CITY OF MERCER ISLAND

September 14, 2021

RE: Request for Information #1 for File No. SUB21-002 – Angiuli Pacific Res Trust Short Subdivision
4001 West Mercer Way, Mercer Island, WA 98040; King County Tax Parcel # 362350-0365

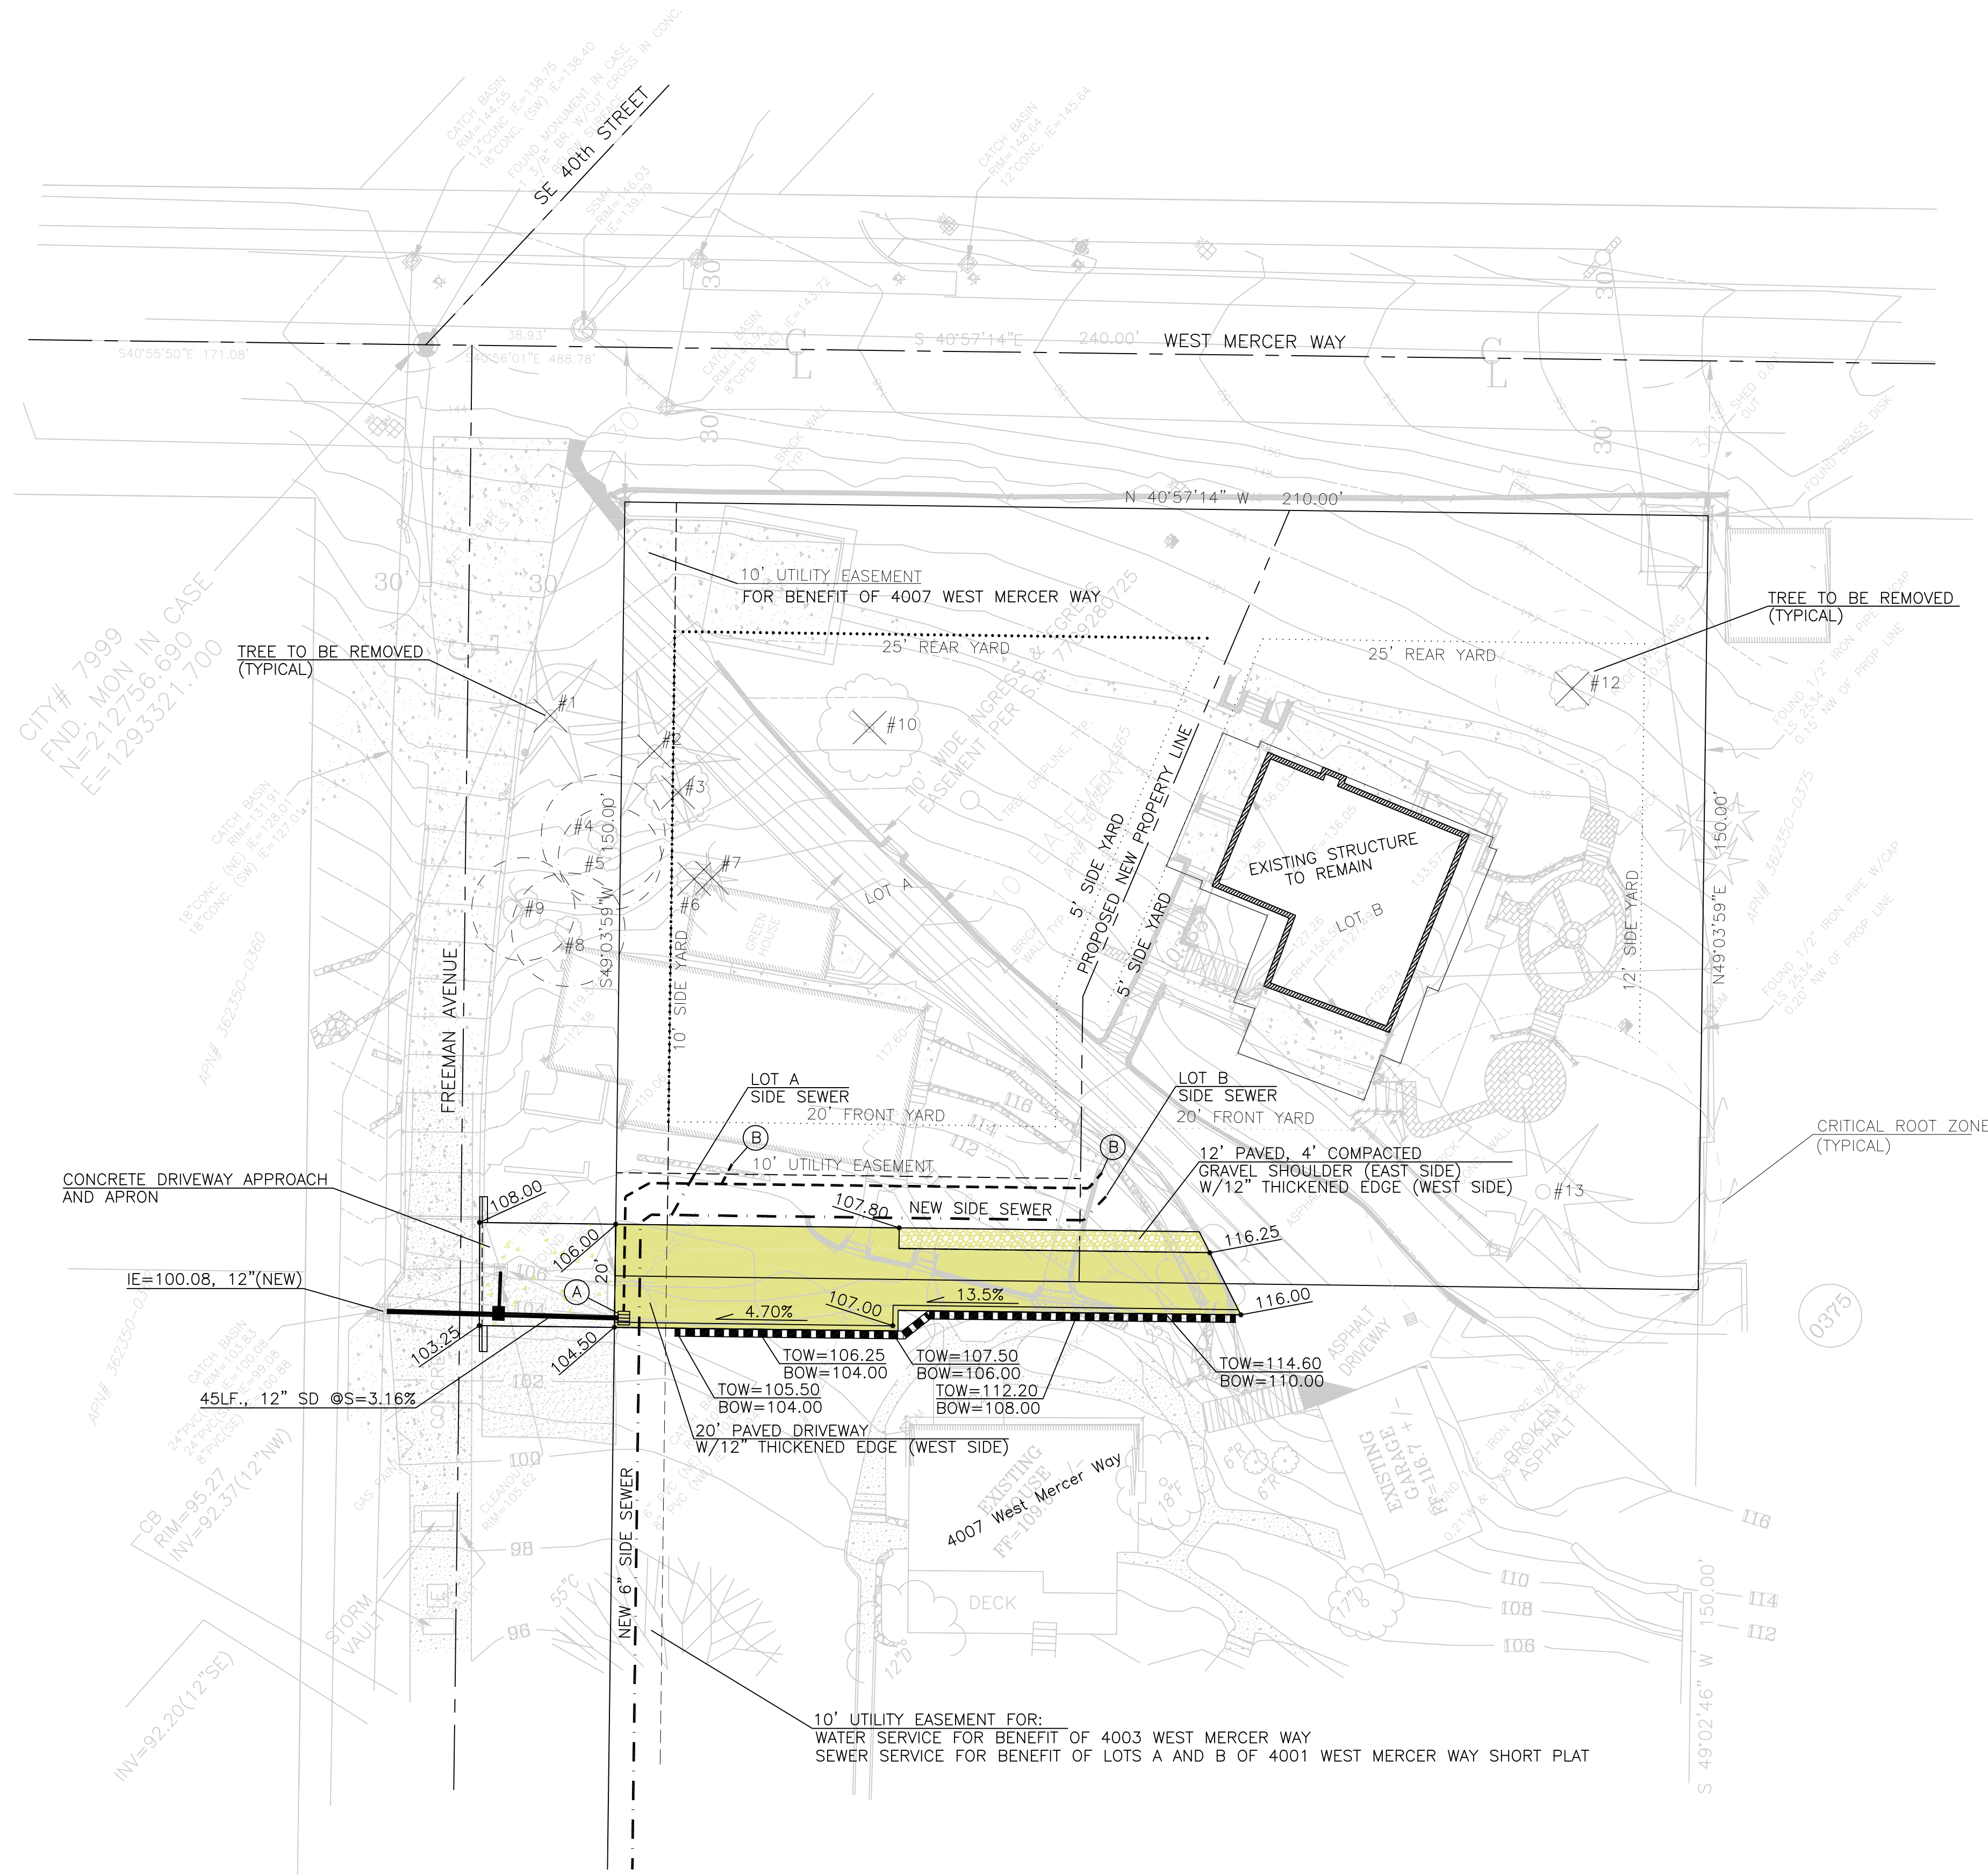
- h. Note Lot A’s southern property line dimension.
- i. Page 6 of 9: Where on Lot A are the 2 covered parking stalls? Are the buildings on Lot A proposed to be demolished or remain?

- 9. Page 4 and 6 of 9: Please clearly distinguish the existing easement and the proposed easement. All easements shall be private easements. Please clearly indicate on the plans.
- 10. Page 2 of 9: Under City of Mercer Island Approvals please change the signature line from “City Manager” to “City Engineer.”

11. Page 6 of 9: Is this the Right-of-Way (ROW) limit? Please label.
